Application no: H01-0422-10

Description: Proposed replacement dwelling and detached double garage

Location: 54 Barrier Bank
Cowbit
Spalding
Lincs
PE12 6AQ
PE12 6AQ

Amendment: Position of gable chimney stacks
Dwg. no. WEN/1357/10/02A

DRAWING:
PROPOSED ELEVATIONS
BLOCK PLAN
SITE PLAN

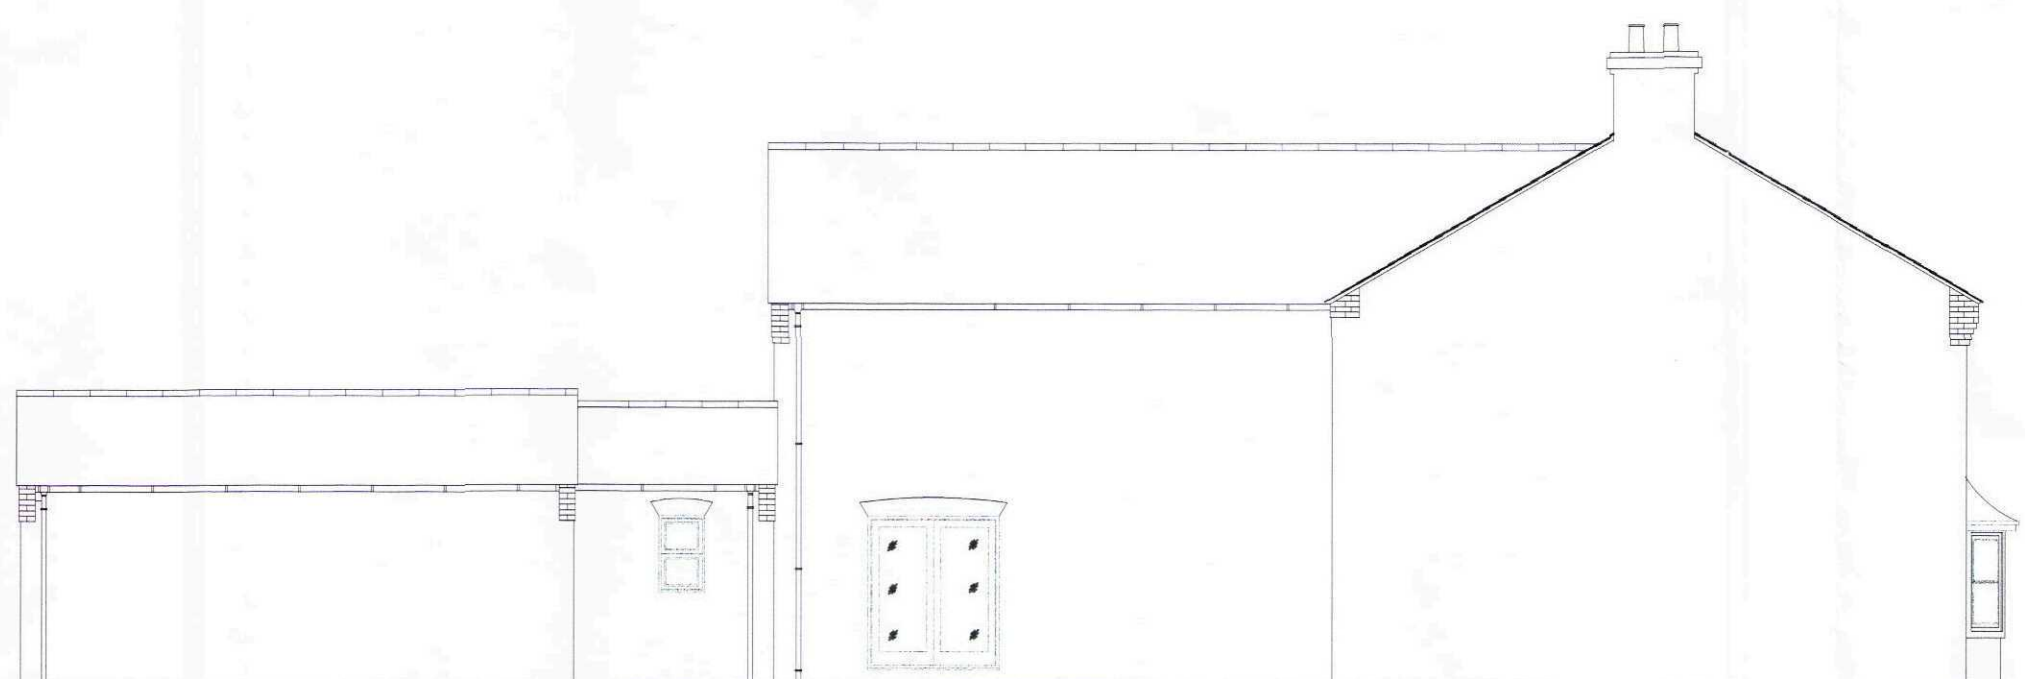
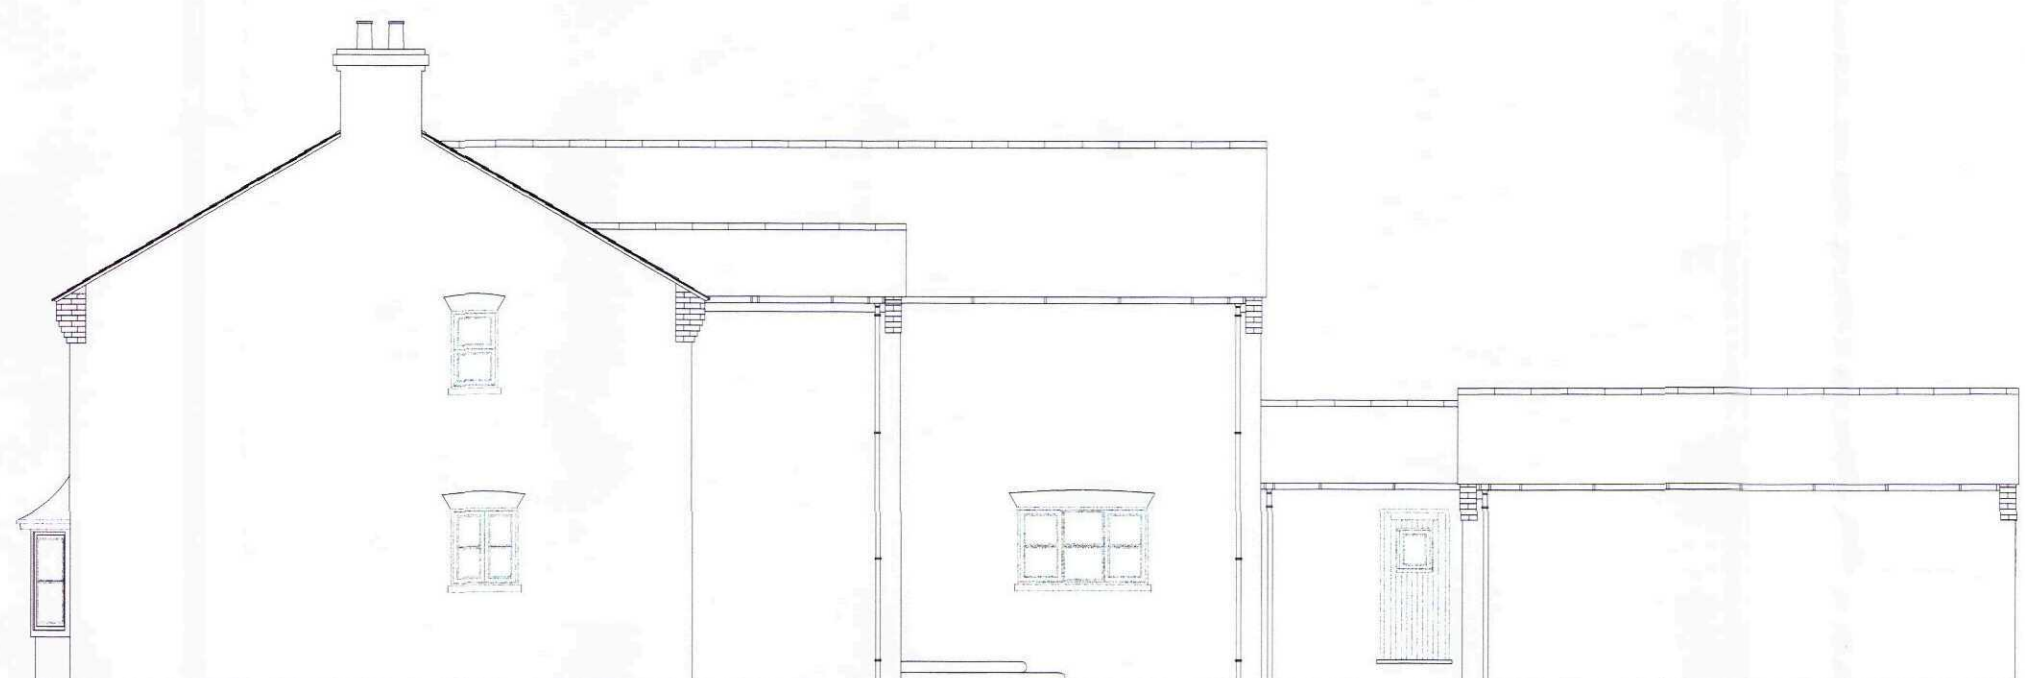
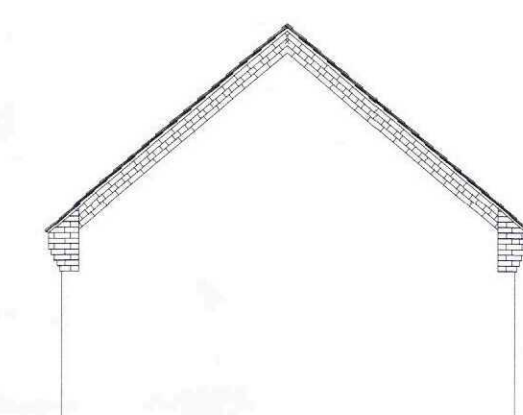
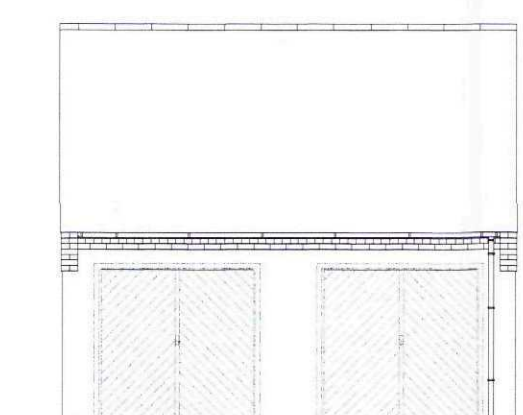
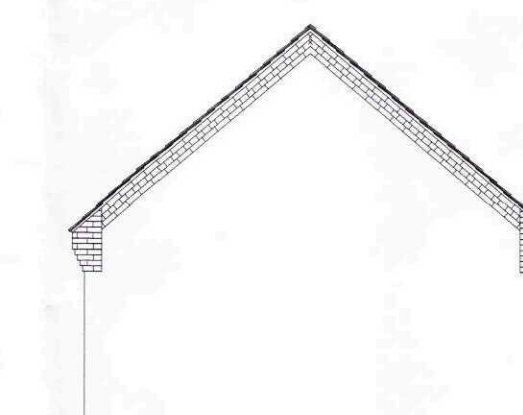
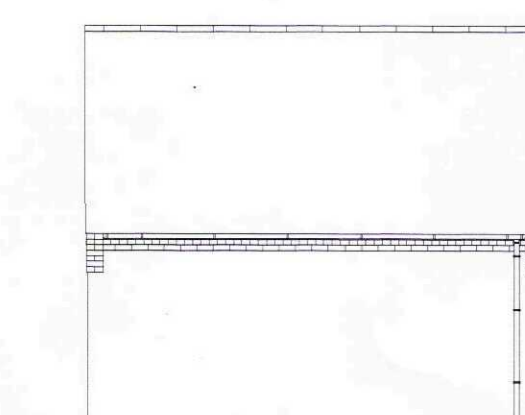
Position of gable chimney stacks

I attach herewith an amended plan showing the chimney stack amended. Hopefully its correct now, any problems let me know.
